Agency Review Comments

Falcon Highlands Fil 3 PUDSP

PUDSP225

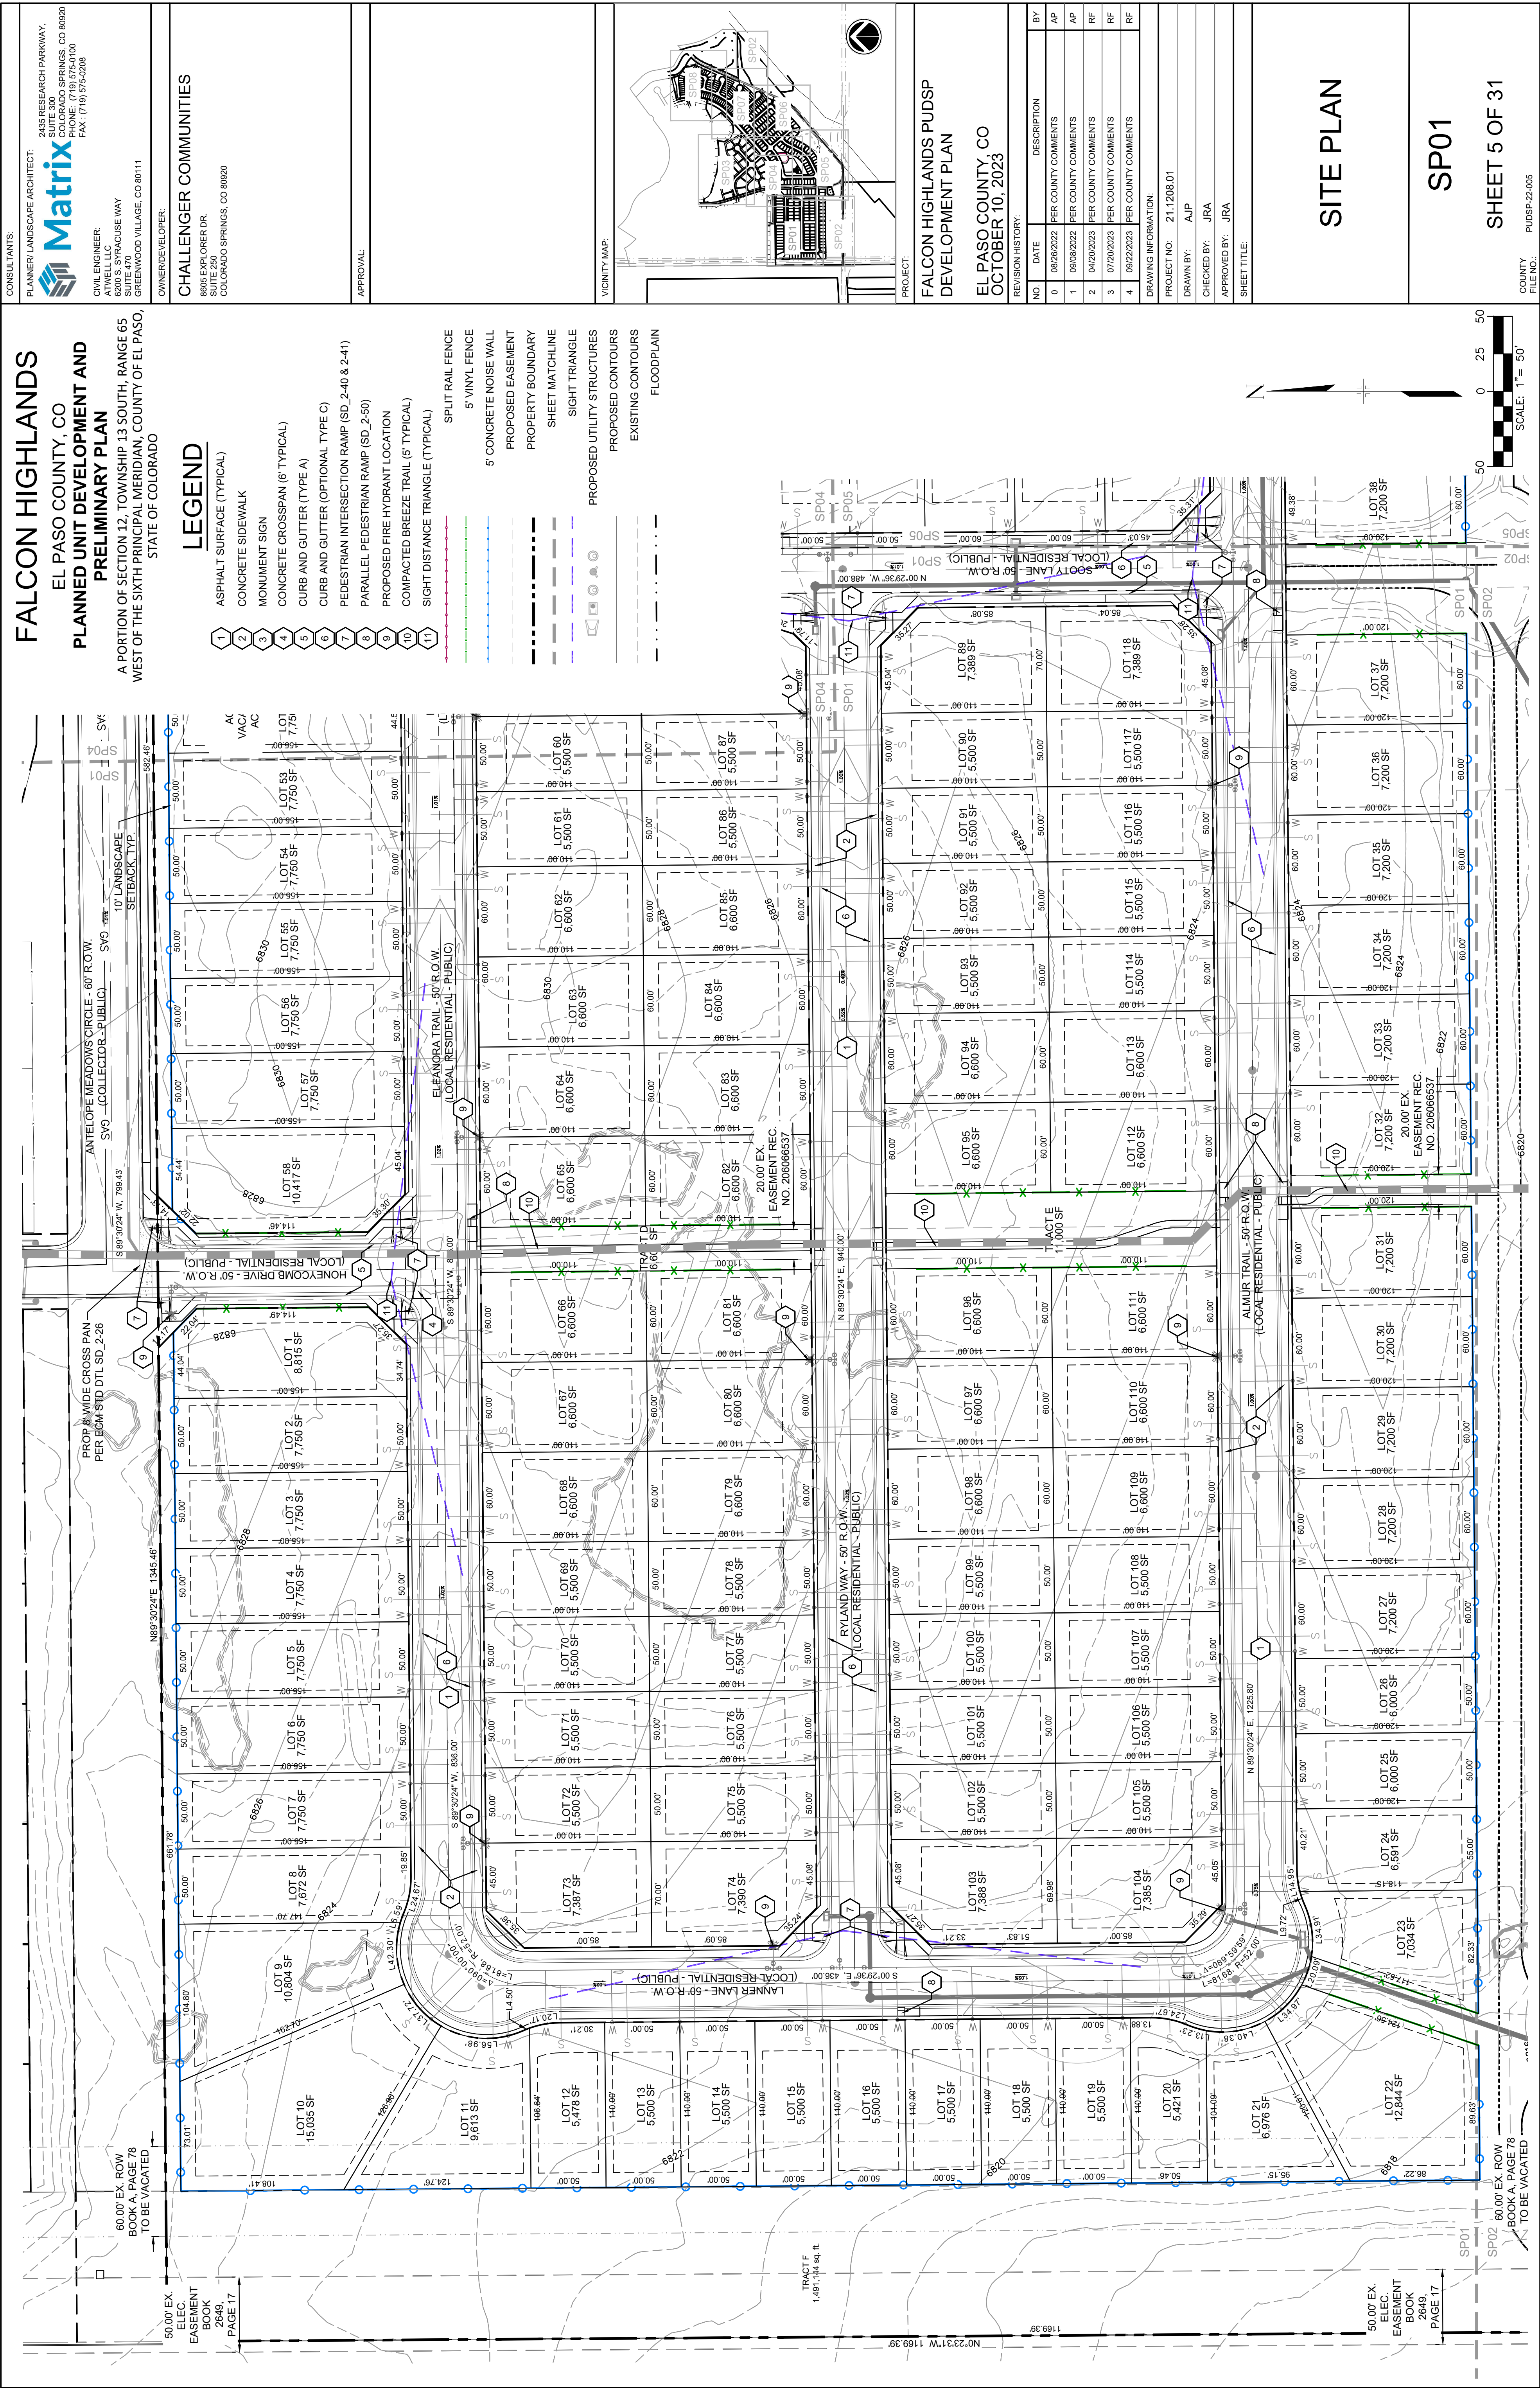
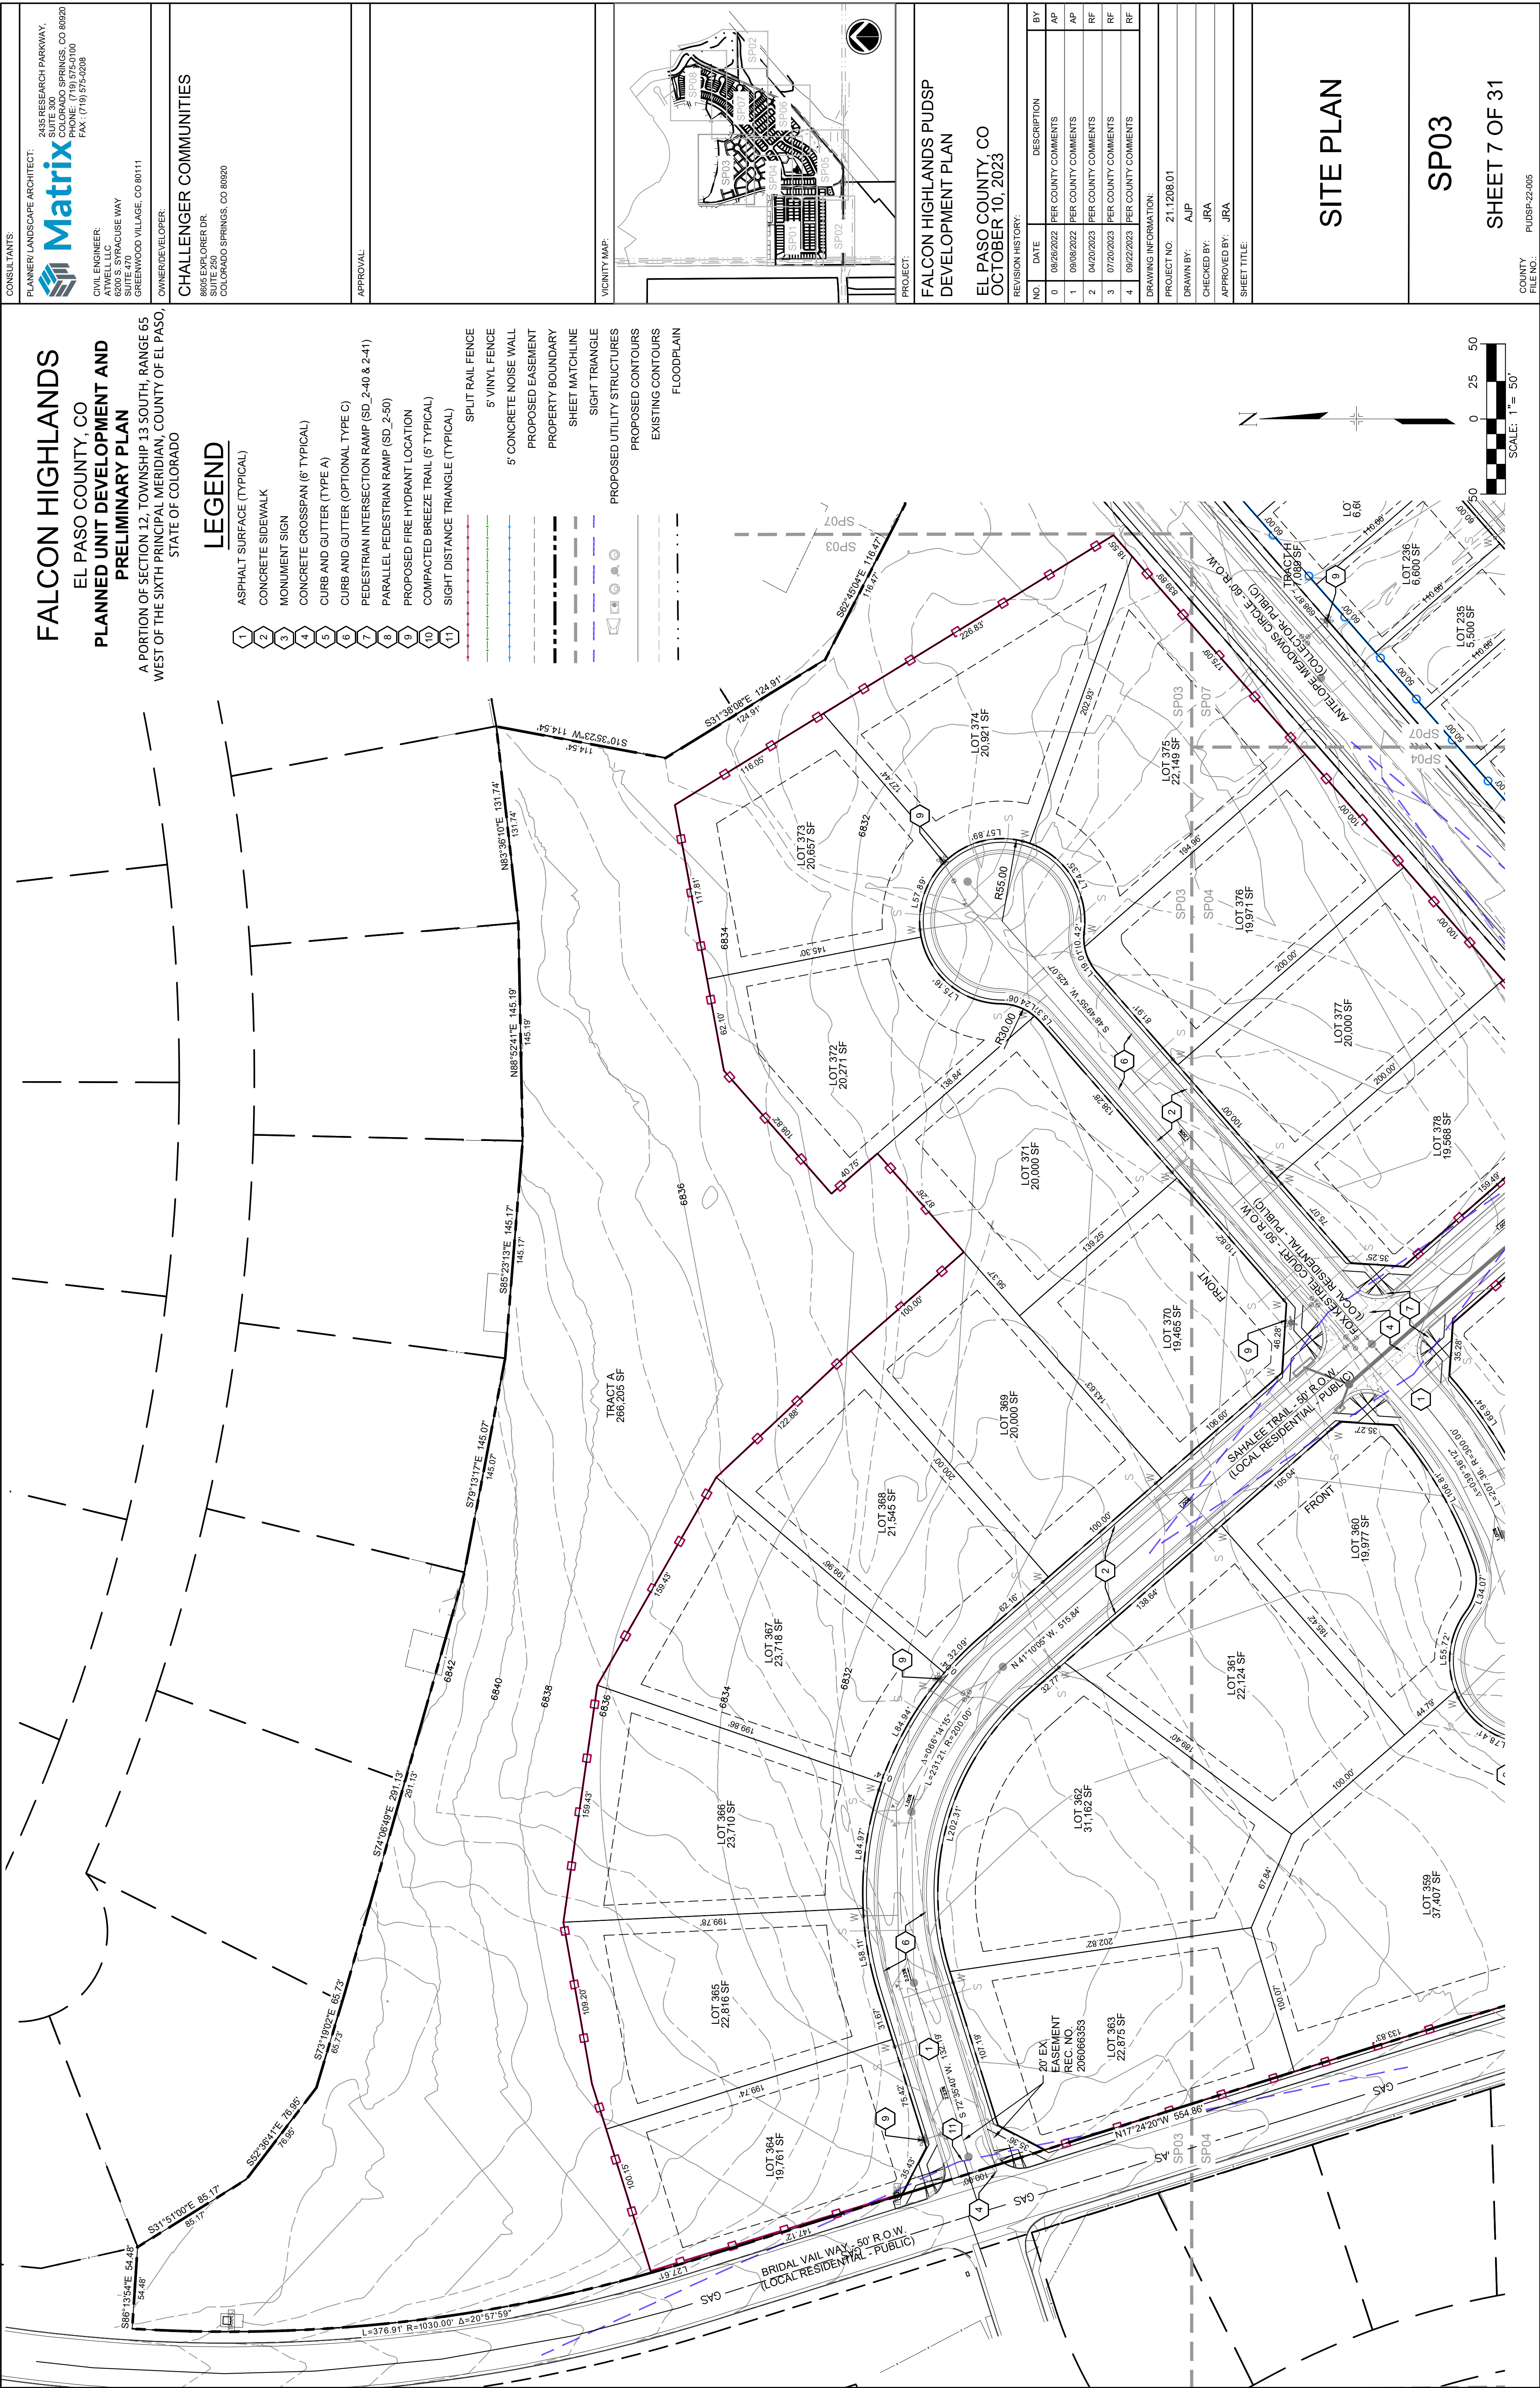
911 Authority - El Paso/Teller County	Streetnames previously approved. Please note: There are a couple of inconsistencies on the plan drawings submitted. - Lanner Ln is incorrectly labeled as Lanner Rod on Pg 5 and Pg 24 - Pg 20 still depicts Pied Harrier Loop instead of Birch Hollow Way looping through.	6/13/2022 8:50:30 AM
---	--	----------------------------

Corrected
